# Villas at Claremont Ranch Traffic Impact Analysis

AUGUST 20, 2021

**Engineering Review**

**EPC Planning & Community  
Development Department**

Figure 4

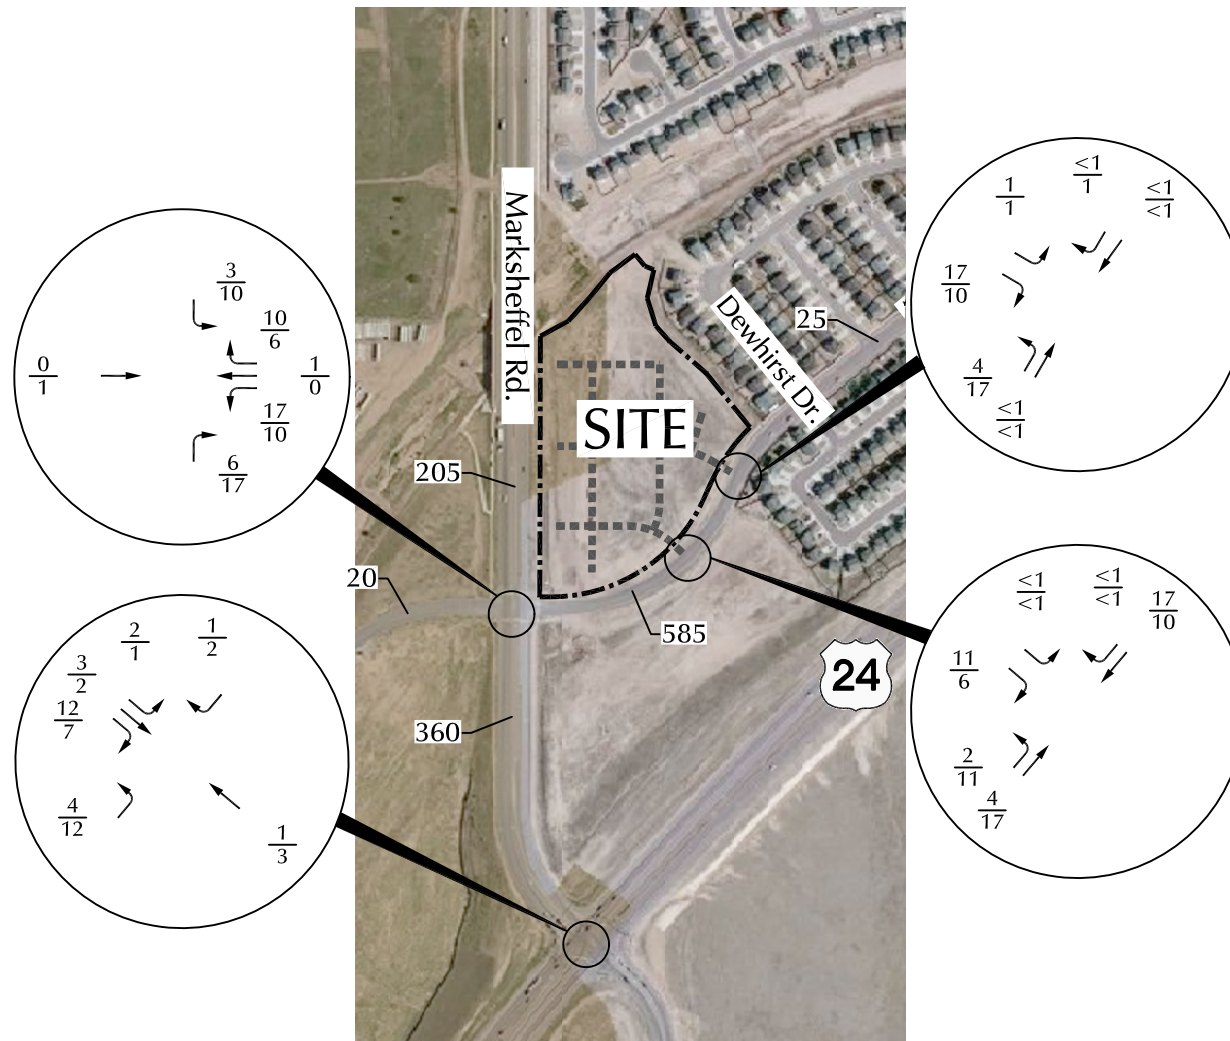
Figure 4 missing in appendix

Figure 6

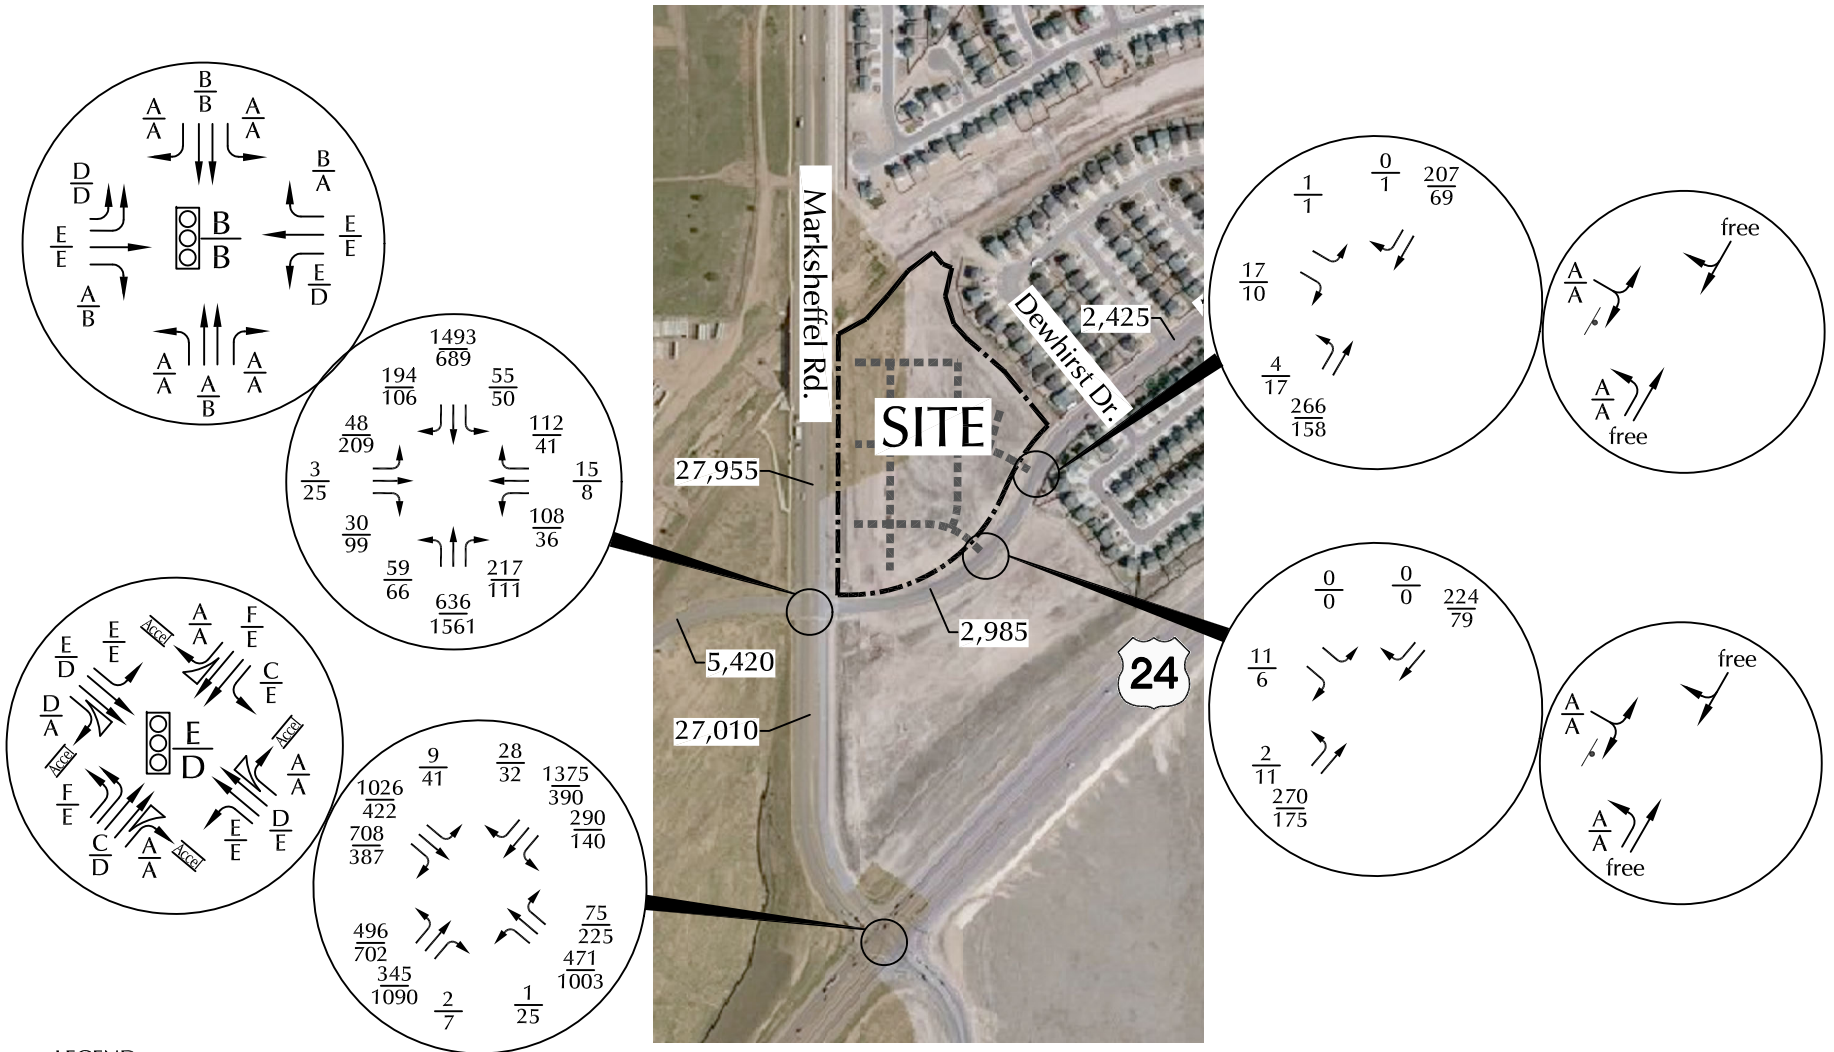
Figure 6 missing in appendix

Figure 7

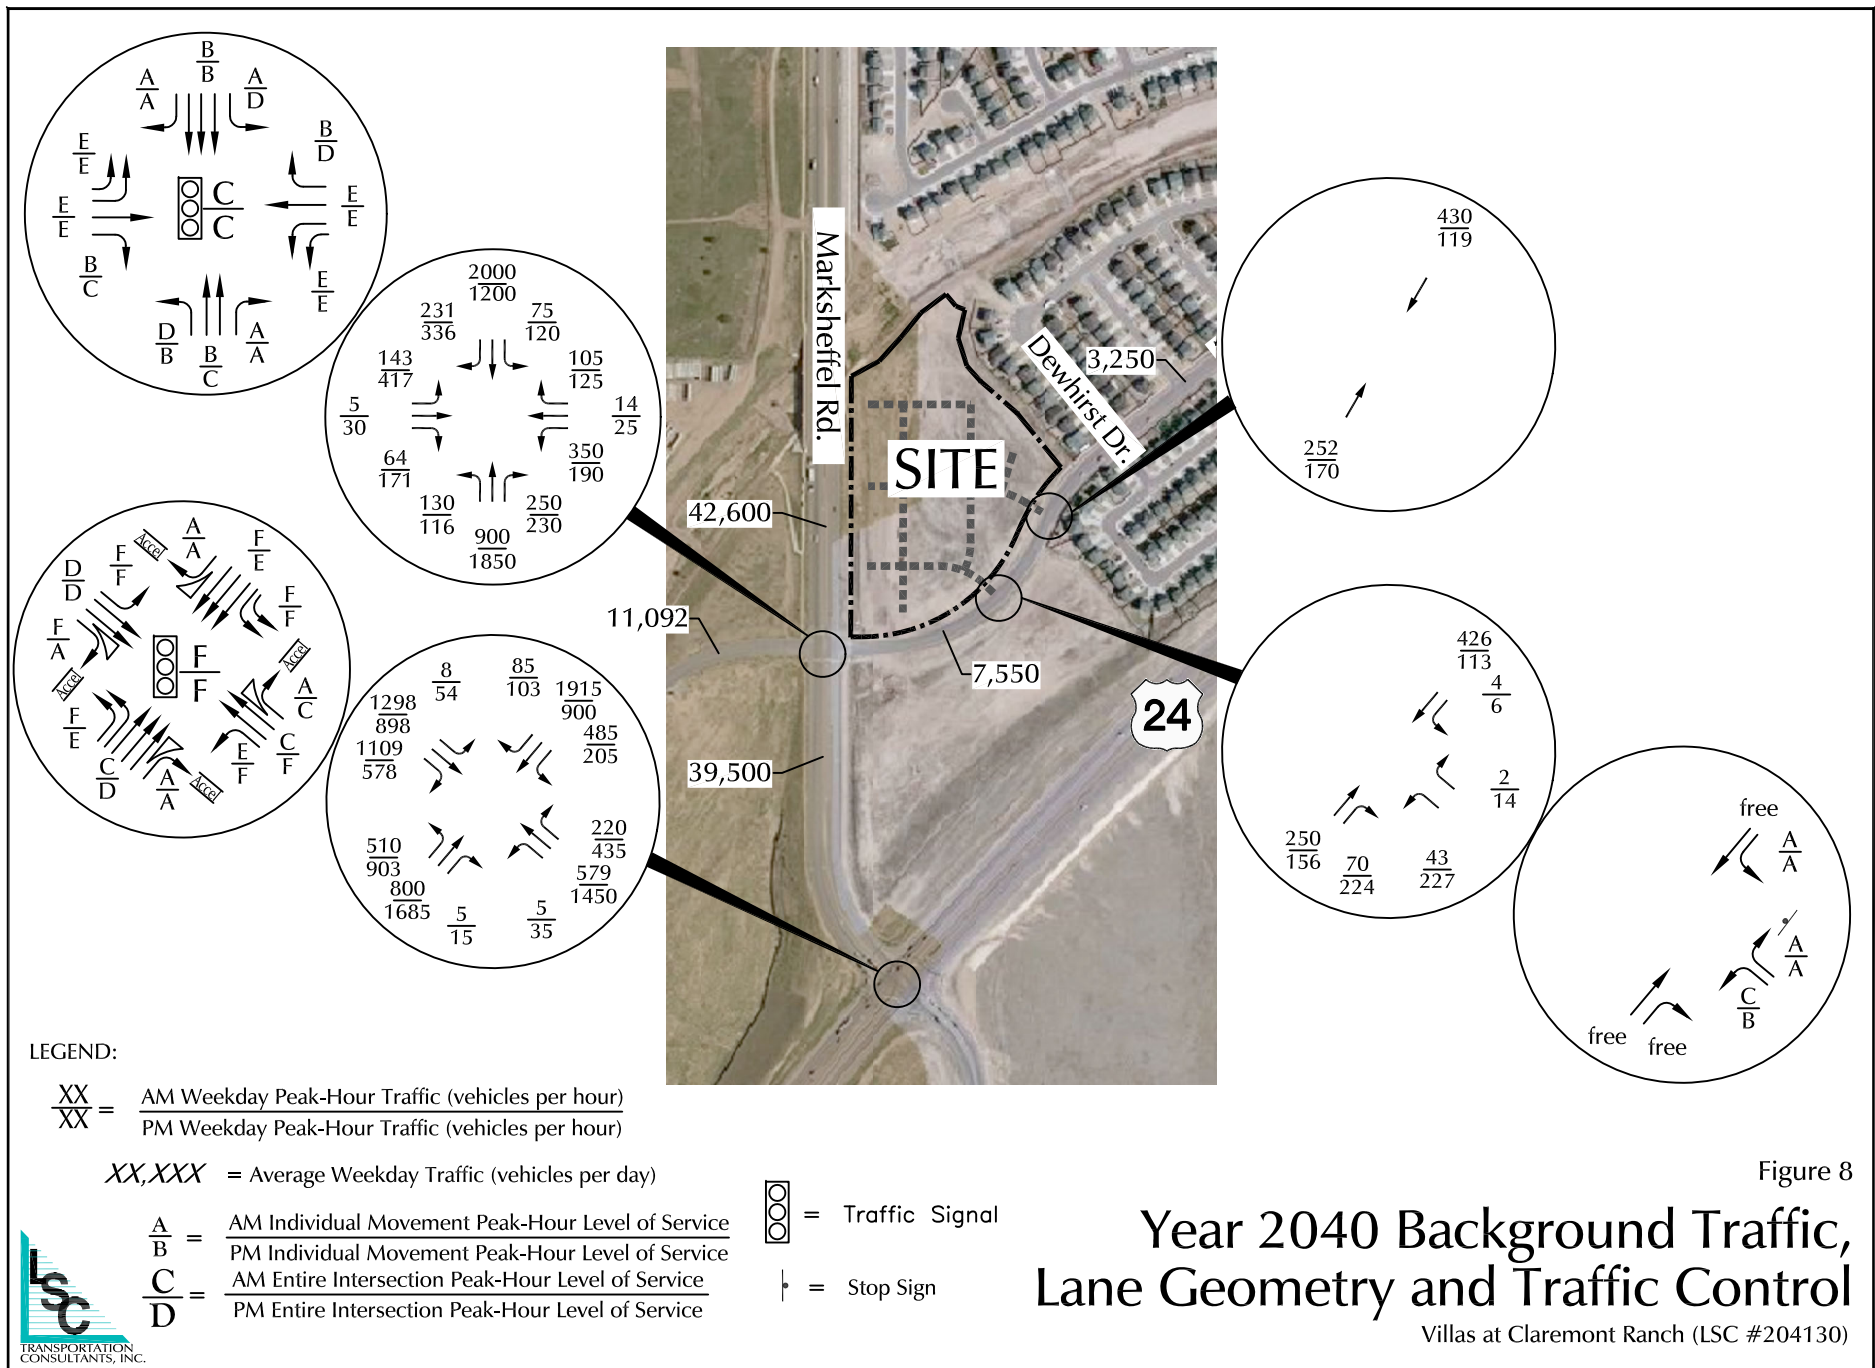
**Short-Term** Figure 7 missing in appendix **Generated Traffic Volumes**

Figure 8

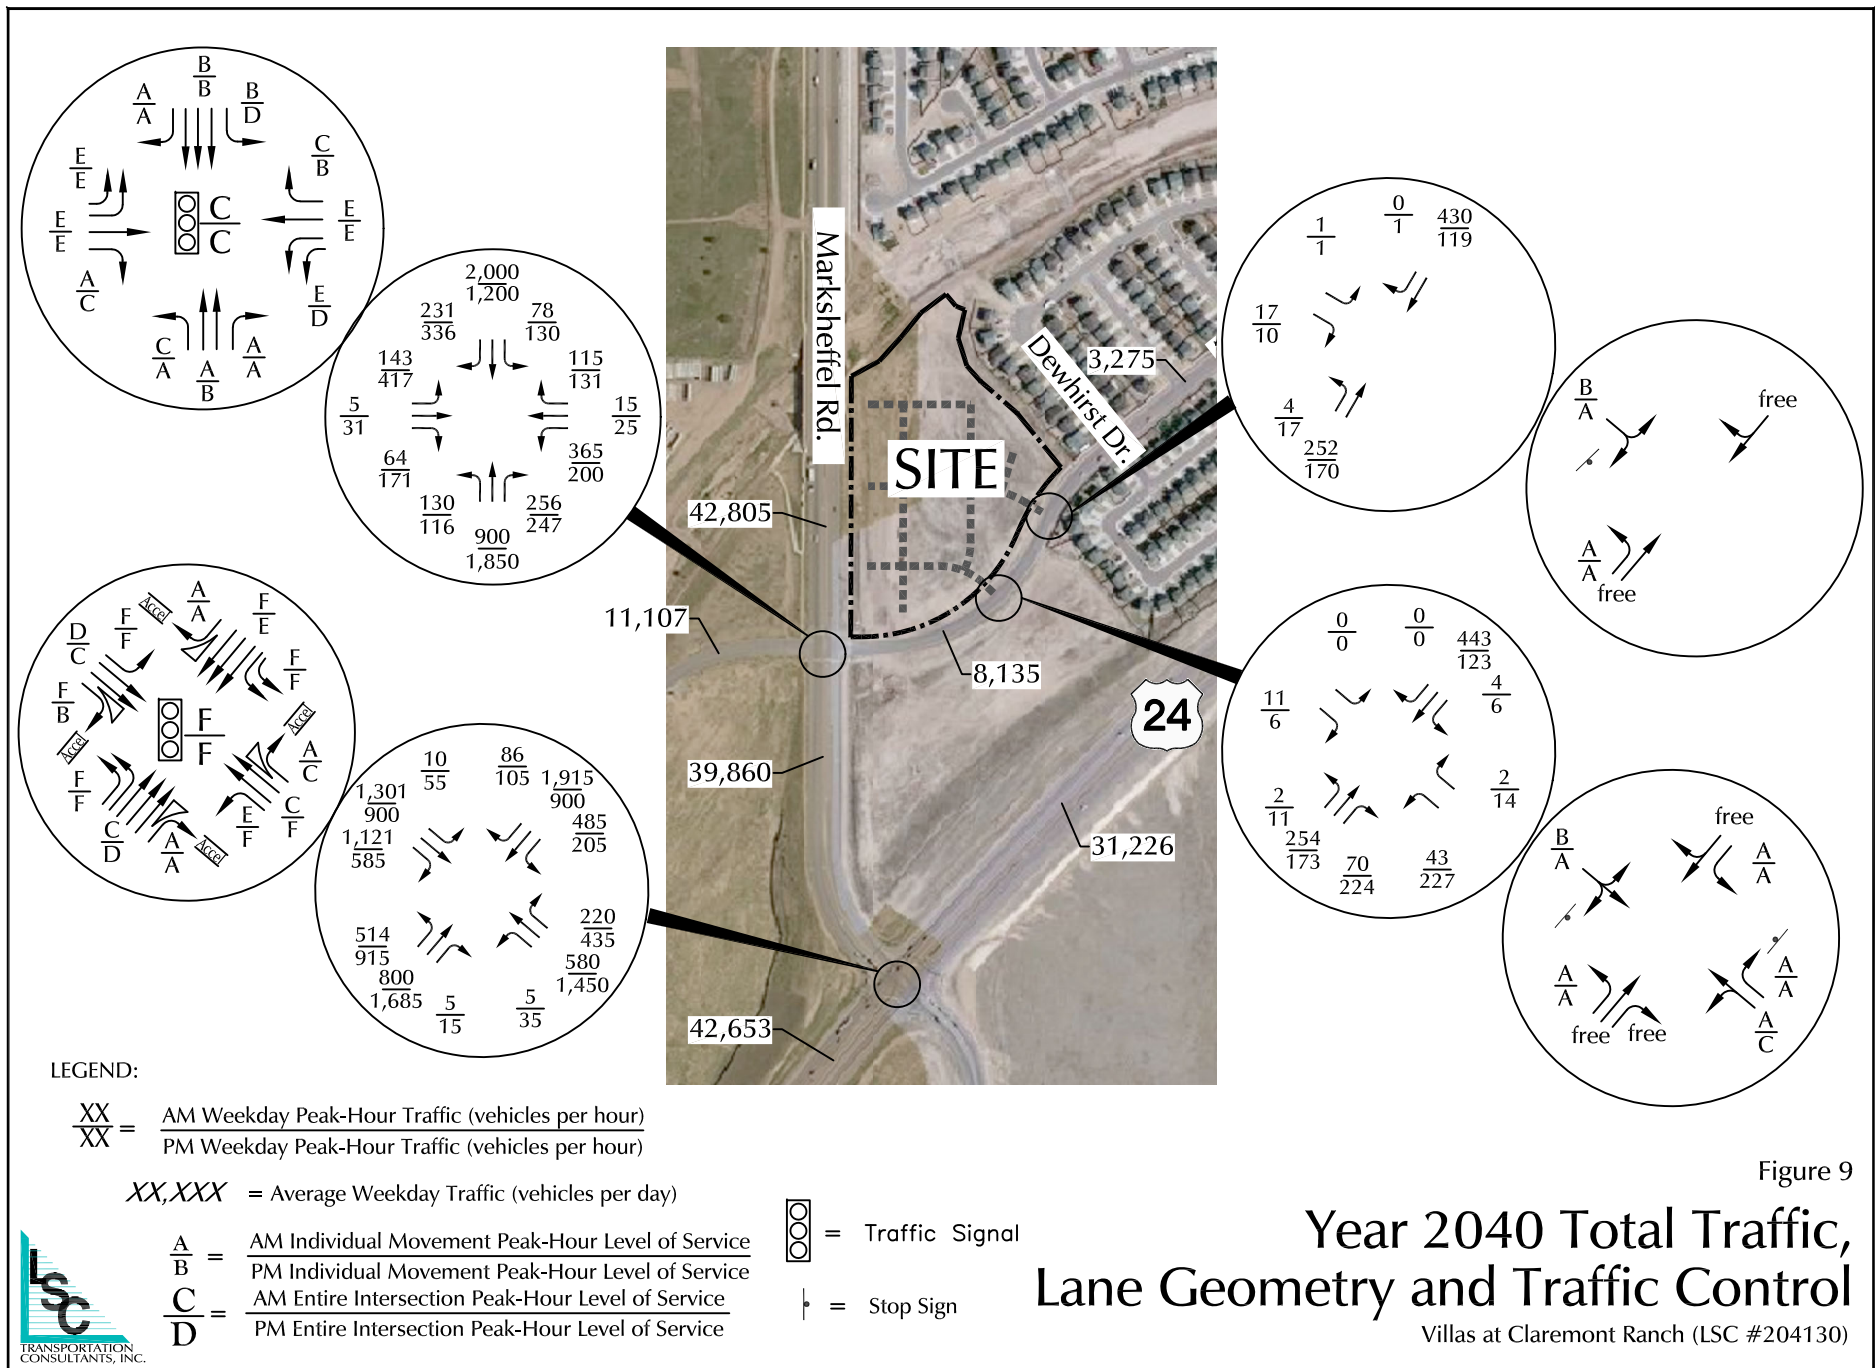
**Long Term Traf** Figure 8 missing in appendix
